Re: Planning Application 19/0063

Address: Land off Higher Road Longridge PR3 2YX

Description: Regularisation of existing, unauthorised agricultural access.

Simon Hardie
Highways Development Control
Lancashire County Council

Block Plan 1:500

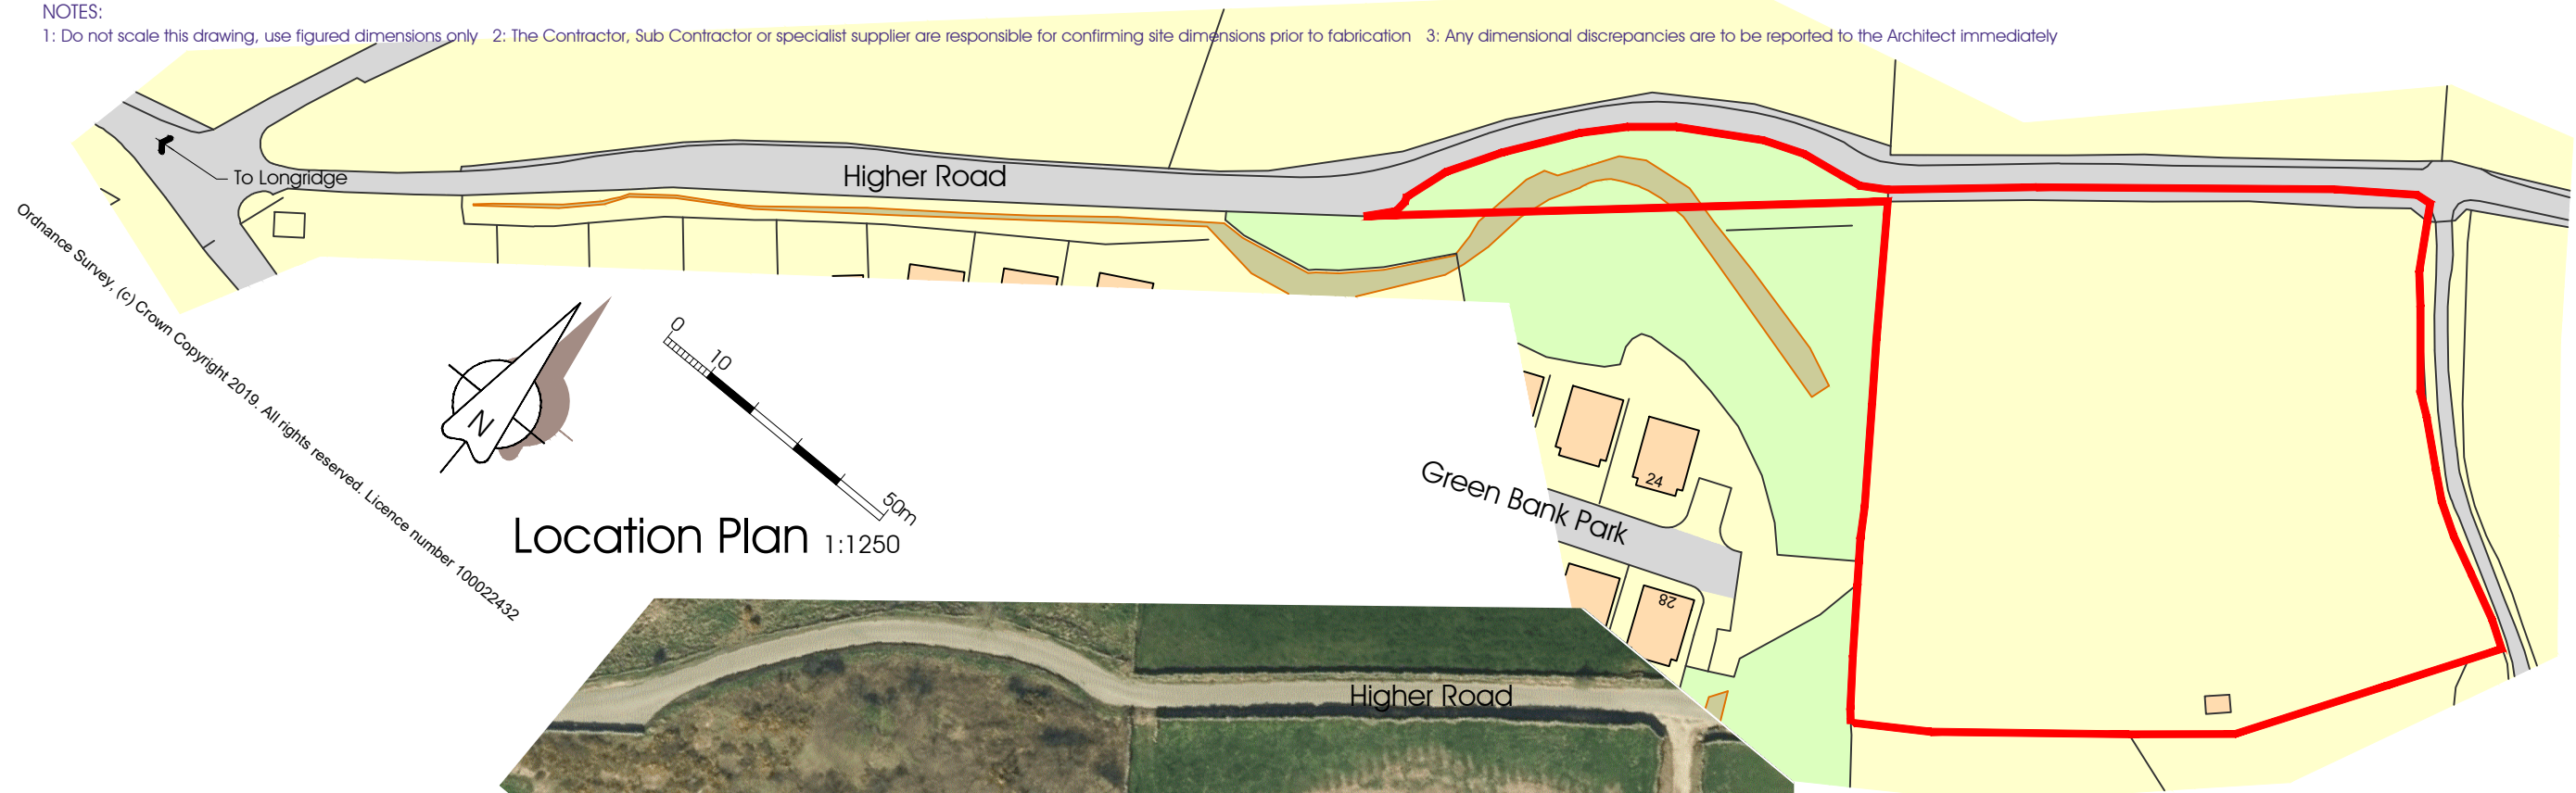
With respect to this application we would not wish to raise any objections to the application. This is based on plan drawn by PGB Architectural Services, Job No. 3088, Drawing No 001, Rev A, Dated 17.01.2019.

1. Before the access is used for vehicular purposes, any gateposts erected at the access shall be positioned at least 5m behind the edge of the carriageway. The gates shall open away from the highway. **Reasons:** To permit vehicles to pull clear of the carriageway when entering and exiting the site and to ensure the swing of the gates do not affect the availability for a vehicle to wait off road.

2. Before the access is used for vehicular purposes, that part of the access extending from the highway boundary to the gate shall be appropriately paved in tarmac, concrete, block pavements, or other approved materials. **Reasons:** To prevent loose surface material from being carried on to the public highway thus causing a potential source of danger to other road users.

3. Notwithstanding the provisions of the Town and Country Planning (General Permitted Development) Order 1995 there shall not at any time in connection with the development hereby permitted be erected or planted or allowed to remain upon the land hereinafter defined any building, wall, fence, hedge, tree, shrub or other device over 1m above road level. The visibility splay to be the subject of this condition shall be that land in front of a line drawn from a point 2.4m measured along the centre line of the proposed access from the

continuation of the nearer edge of the carriageway of 2 to points measured 100m in each direction along the nearer edge of the carriageway of Higher Road, from the centre line of the access. Reason: To ensure adequate visibility at the street junction or site access.
